Freedom Forever
Planset Revision Letter

9/6/2024
REV #3

PATRICK NORRIS
221 RED CEDAR WY , FUQUAY-VARINA, NC 27526

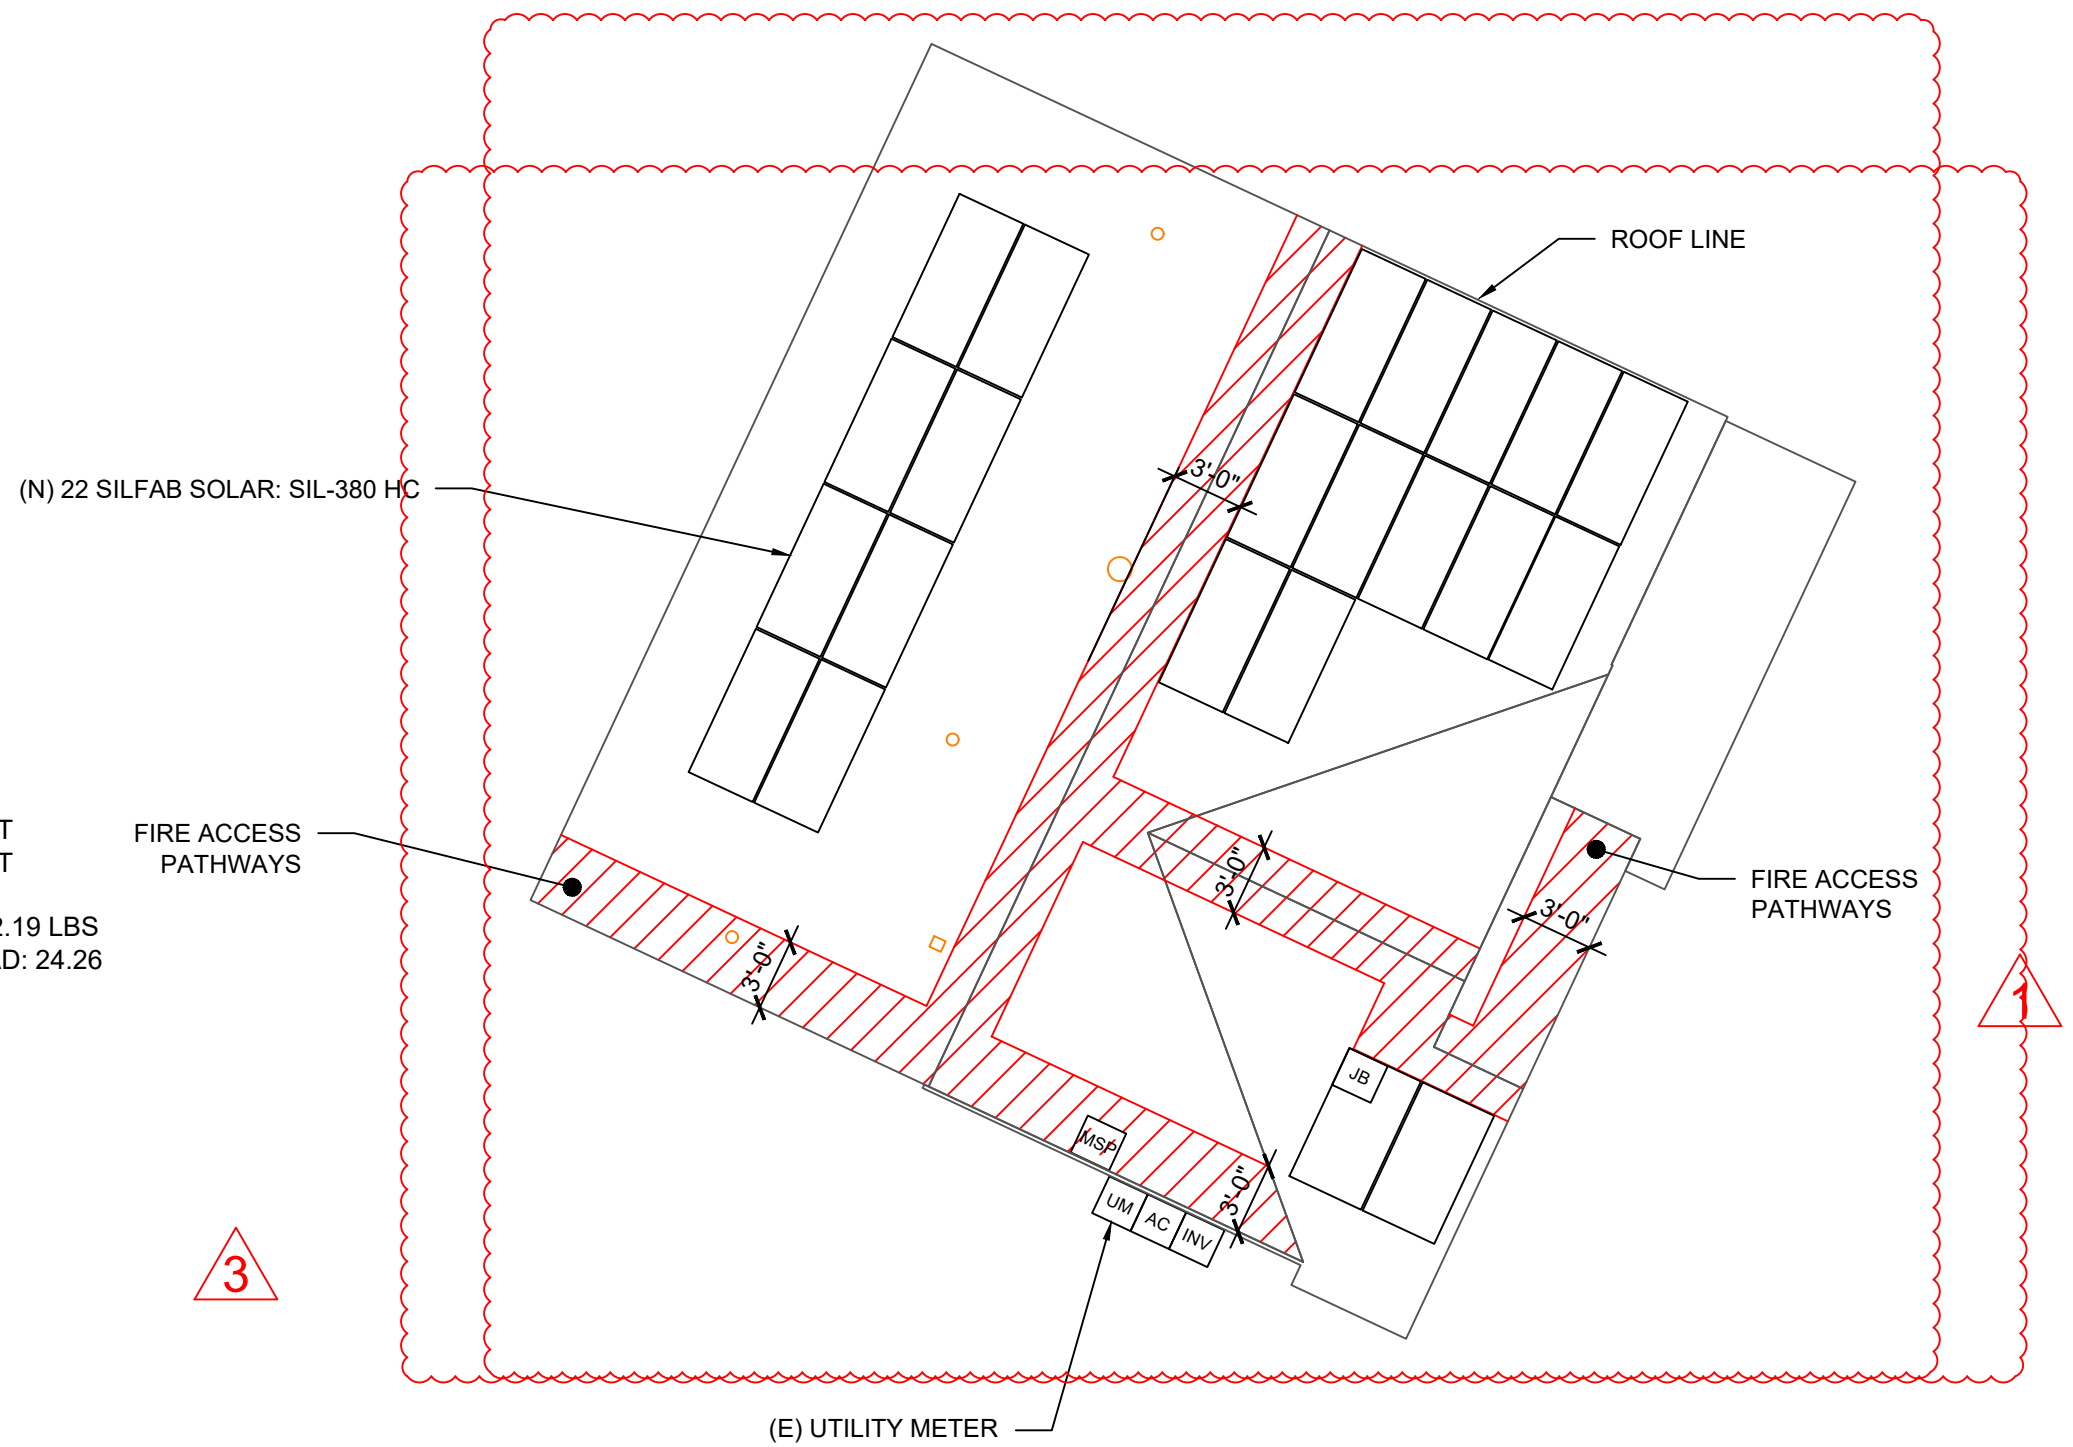
SINGLE MODULE SHIFT TO ARRAY 1
